Ribble Valley Borough Council
Council Offices
Church Walk
Clitheroe
BB7 2RA

Your ref: 3/2021/0275
Our ref: DC/21/1403
Date: 18-AUG-21

Location: Land behind The Dog Inn, Market Place, Longridge PR3 3RR
Proposal: Proposed erection of 9 new dwellings and associated works

Thank you for the new information received by email on 4 August. United Utilities Water Limited ('United Utilities') wishes to provide the following updated comments with respect to the interaction with the public sewer. Whilst the newly submitted information is helpful, it has not addressed all of our previous queries. Our latest position is therefore set out below.

Site Section through The Dog Inn, Plot 2 and 36 Darwen Close

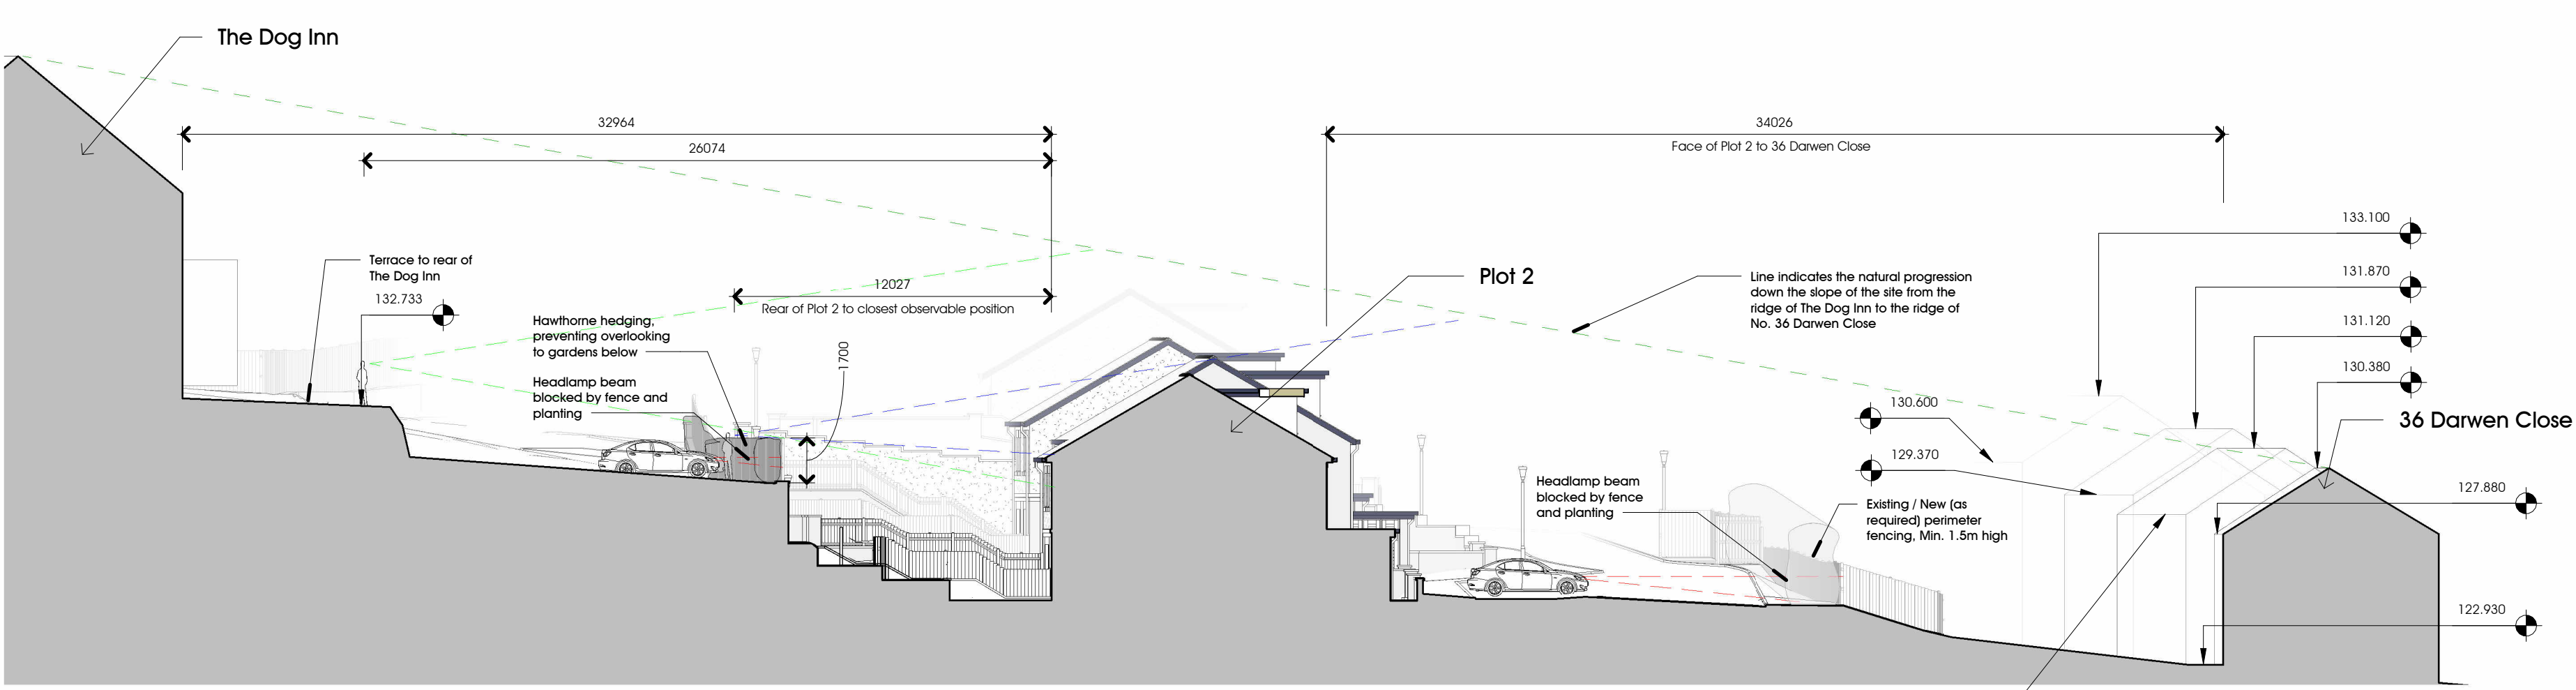
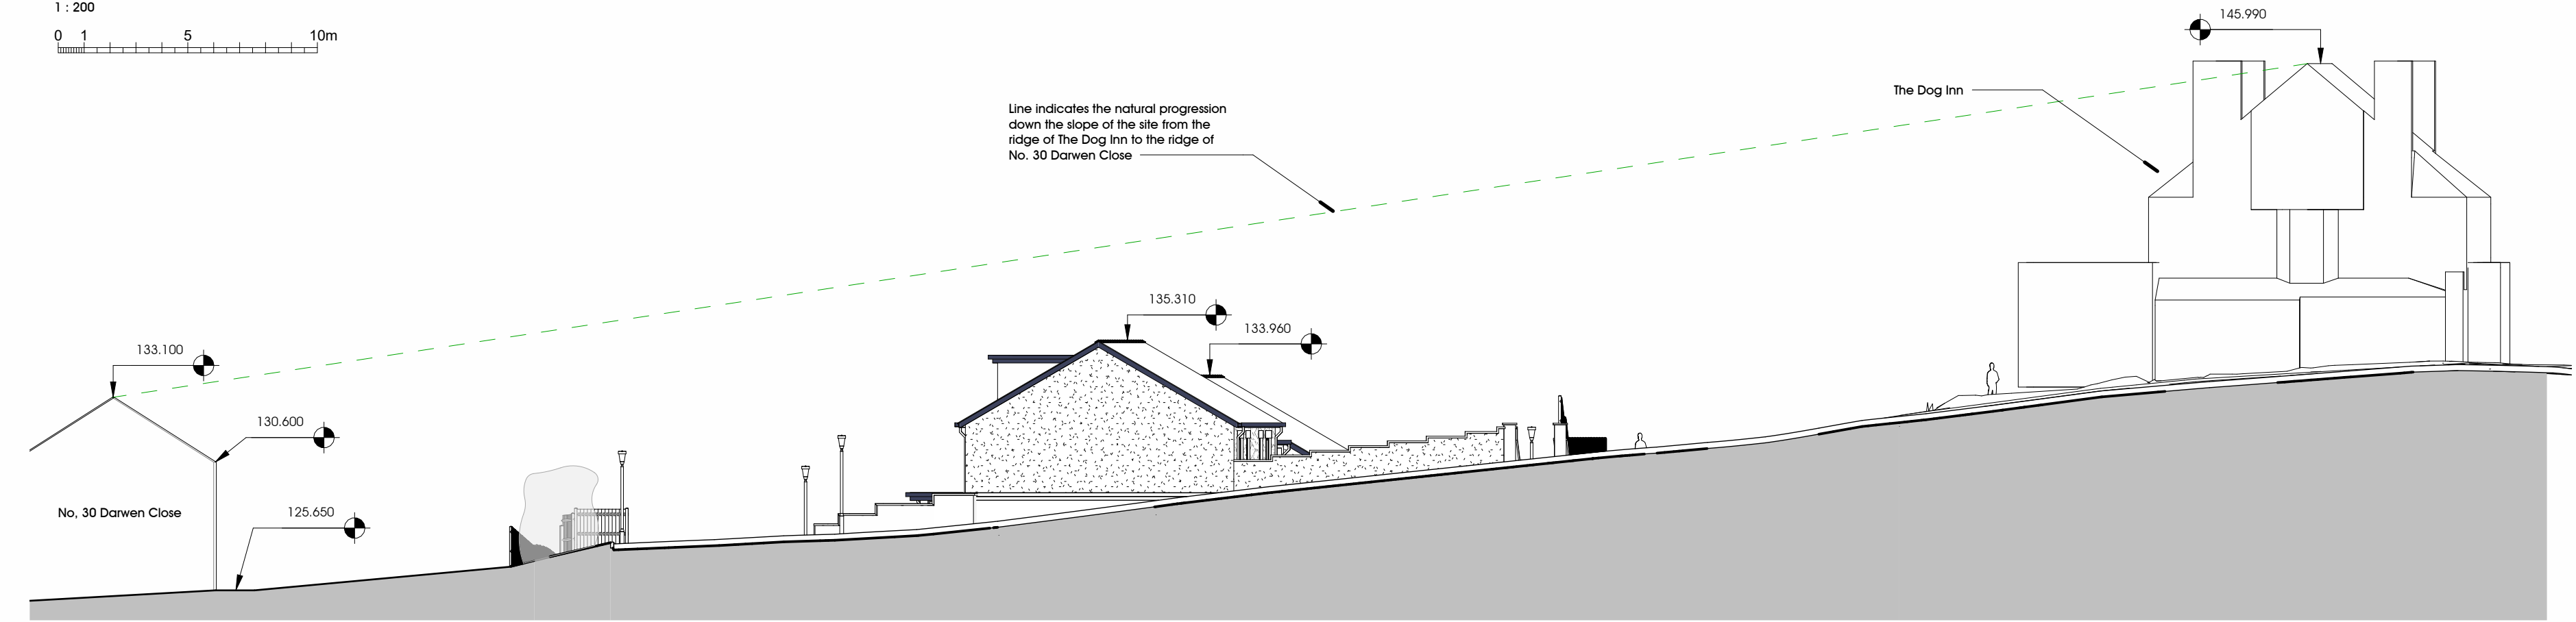
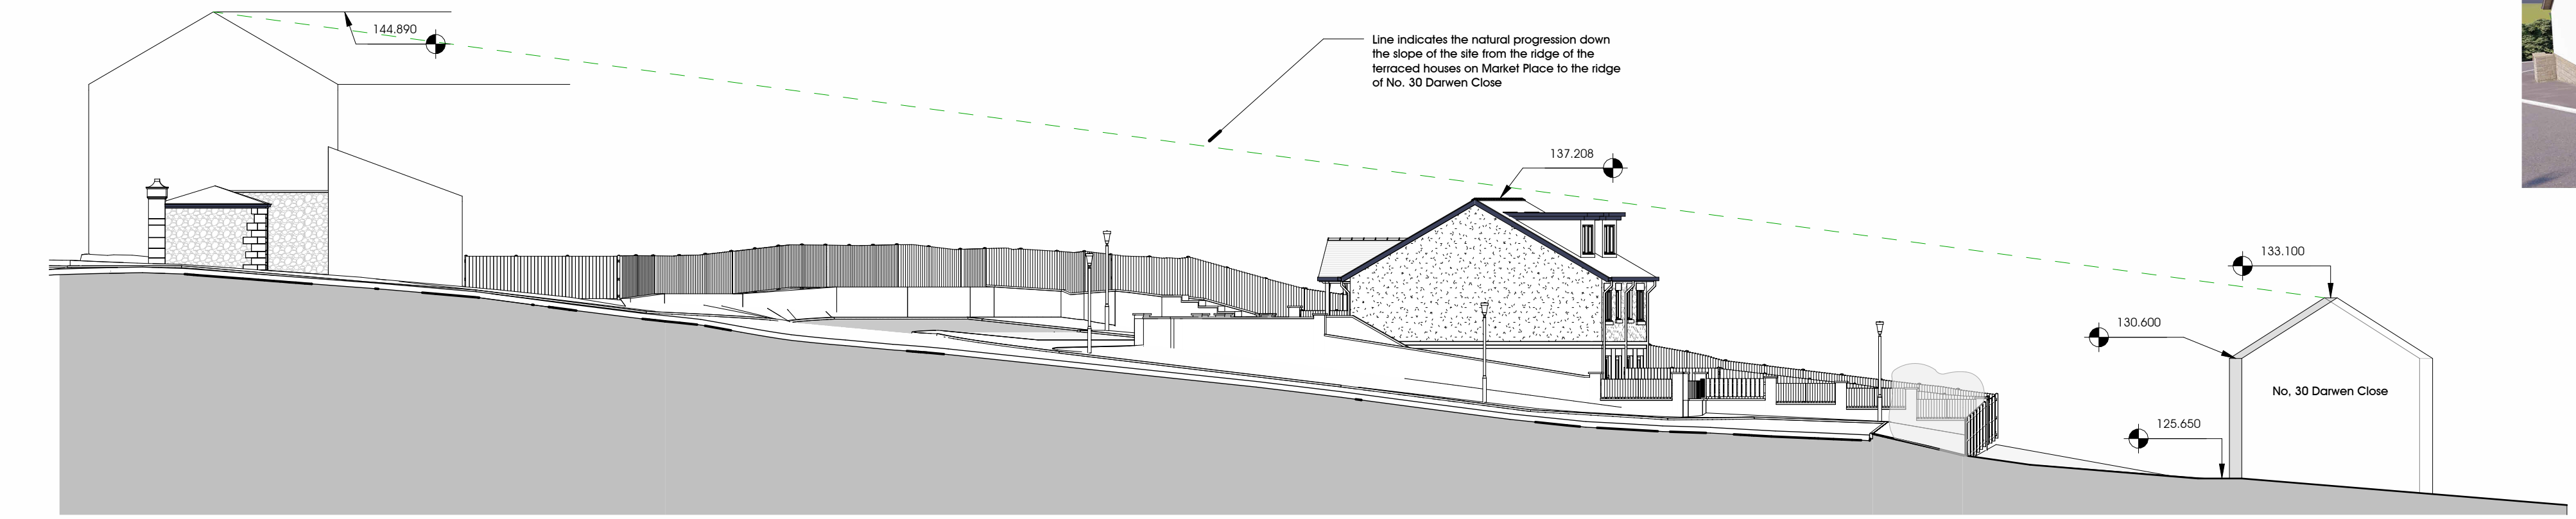
- 2) Previously we noted that with regards to the proposed ground levels, the submitted site sections indicate a reduction in ground levels around various plots such that the buildings will be significantly lower than surrounding land and the cover levels on the existing sewer that passes through the site. We therefore continue to request that the applicant confirms finished floor and ground levels and the overland flow and exceedance paths from surface water and in the event that the retained element of the sewer surcharges from existing / proposed drainage systems. It will be important that the final topography of the site guides the flows from any surcharged manhole away from the proposed dwellings and their associated curtilages where possible.

- 4) In our previous correspondence we noted our review of the submitted cross section in relation to the sewer and expressed our concerns at the proposed approach. Noting our concerns regarding the absence of evidence to confirm connectivity to the retained elements of this sewer and the absence of a cross section relating to elements of the sewer that the applicant proposes to retain as public; our previous concerns have not been fully addressed. We previously noted that the cover on top of the existing sewer that passes through the site is proposed to be reduced to as little as 0.482m. This is not acceptable to United Utilities and needs further consideration with our Developer Engineer. We also expressed our concern that the proposed retaining wall arrangement within the rear gardens will compromise access to the public sewer for maintenance, repair or replacement. In conclusion, further discussions will be necessary with our Developer Engineer to fully understand what elements of the sewer need to be diverted to facilitate this scheme after obtaining a full understanding of any change in levels and connectivity. This will need to be addressed as part of a sewer diversion under s185 of the Water Industry Act 1991. Any diversion of the public sewer will be at the applicant's cost.
